03/05/2019

**Marulan South Limestone Mine Continued Operations Project (SSD-7009)
Response to Submissions**

Attachment A

The Project - Disturbance footprint

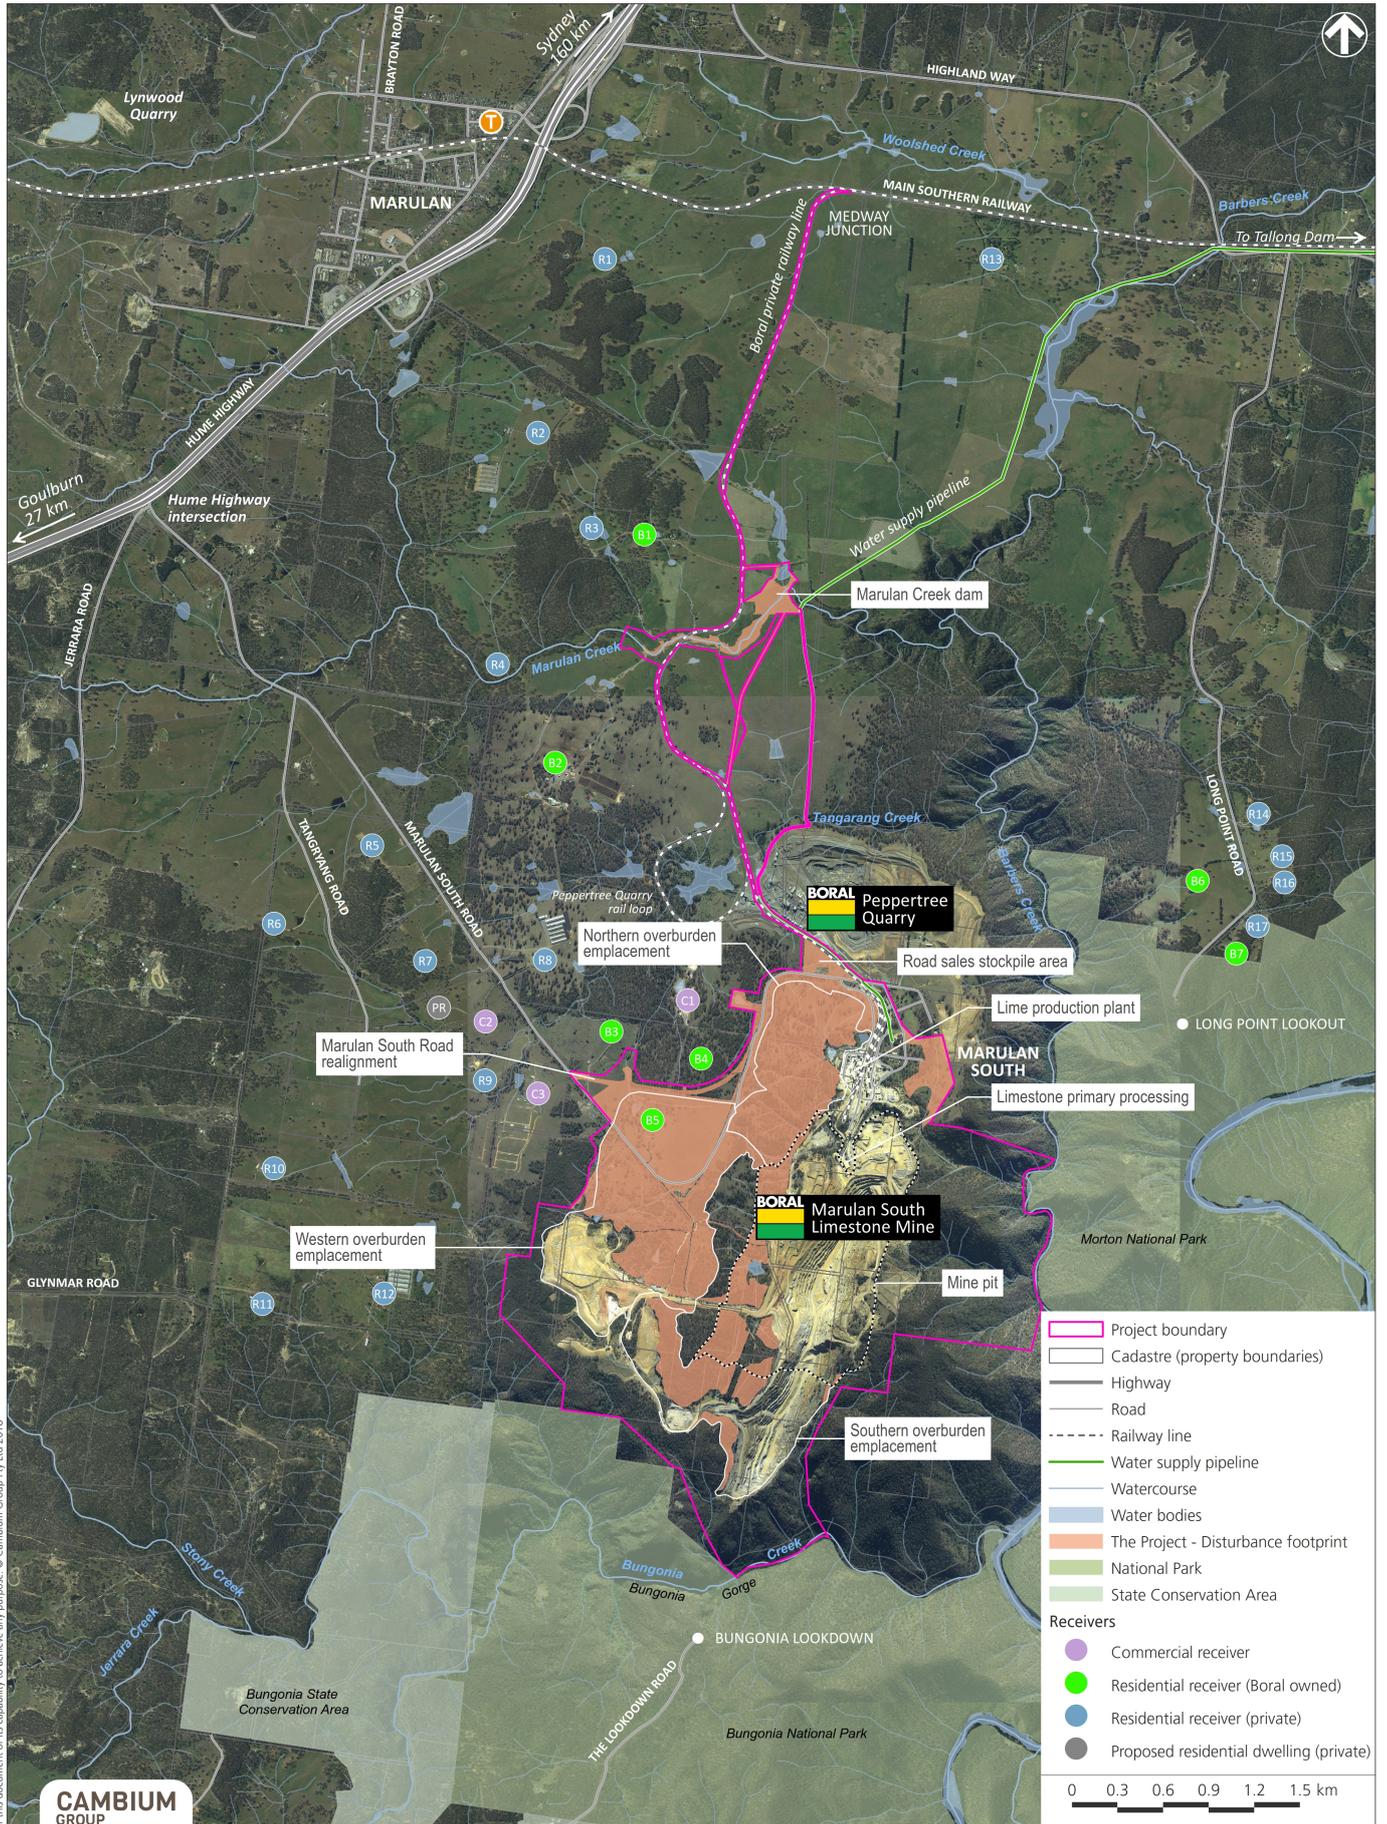
4. Section 6.2.3 of the Surface Water Assessment indicates that Stage 1 of the project includes the upgrading of the Tallong Dam pipeline to facilitate the connection of the proposed Marulan Creek Dam to Boral's existing on-site reservoir. The Department requests clarification as to whether this upgrade would be wholly contained within the proposed disturbance footprint, as shown in Figure 4.1 of the EIS.
